DECISION DELEGATED TO HEAD OF PLANNING

Application No: H05-0861-25 **Applicant:** Mr A Wright
Proposal: Proposed Dwelling
Location: Adjacent To 14 Cross Street Fleet Spalding
Terminal Date: 10th November 2025

Proposed Block Plan (1:250)

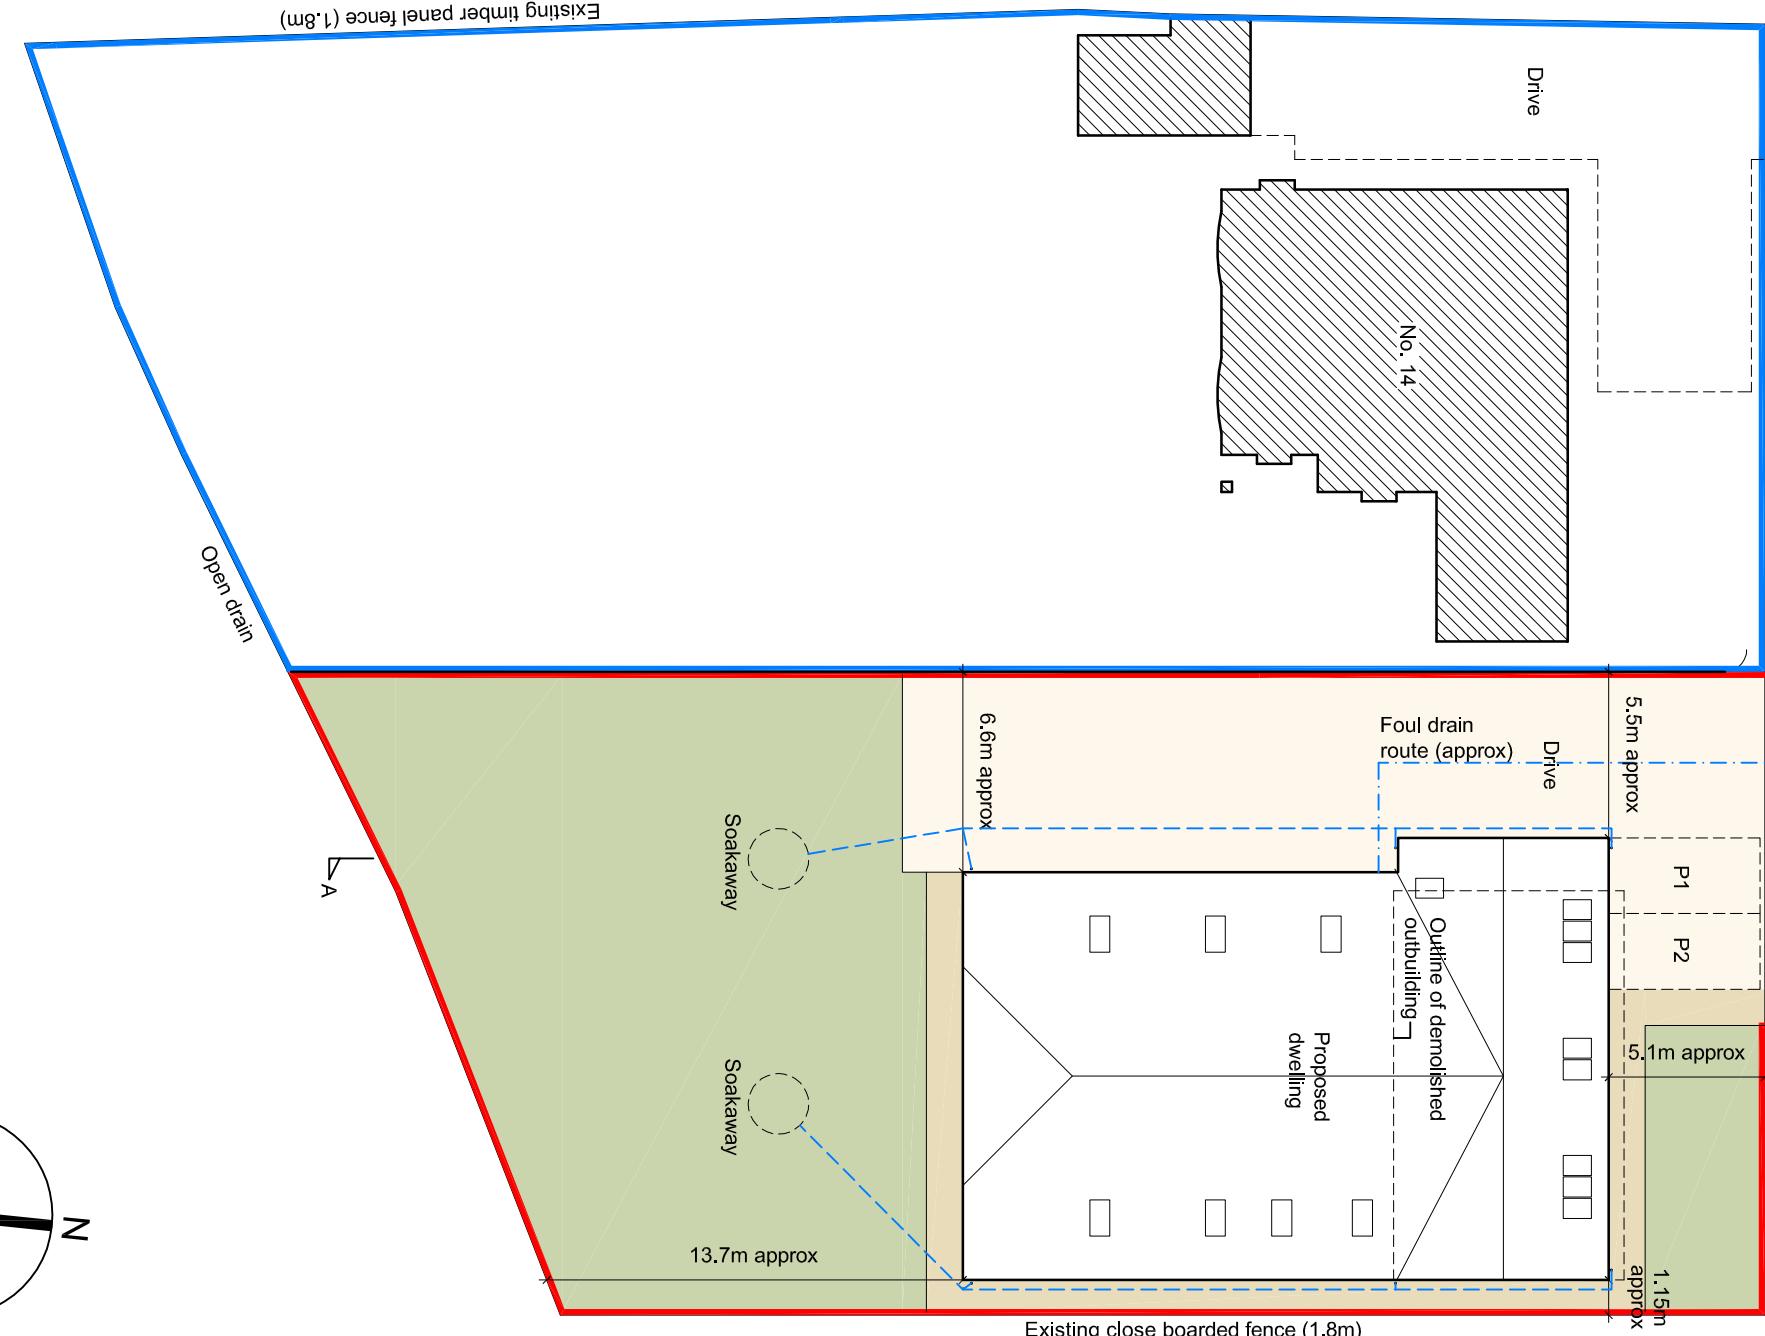
The siting of the dwelling is such that it lies beyond the front of No.14 Cross Street (albeit by a minor extent), the northernmost projecting dwelling along this side of Cross Street. In addition, the extent of the dwelling is such that the rearmost elevation of the proposed dwelling lies further south within its plot, than that of the eastern neighbour No.18 Cross Street, which itself lies notable more to the south than the eastern neighbouring plot. In total, 296.6sqm, in the form of a 14.62 (maximum) width by 21.7m projection (maximum) is proposed. The result of which gives rise to an extensive and large massing and bulk.

In light of this, the proposed dwelling would extend significantly beyond the existing neighbouring dwelling of No.14 and would extend notably beyond the front of No.18, whilst comprising an extensive built form as to extend beyond the rear of this neighbouring dwelling also. This further emphasises the significant mass and bulk of the proposed development, which appears incongruous with the wider area.
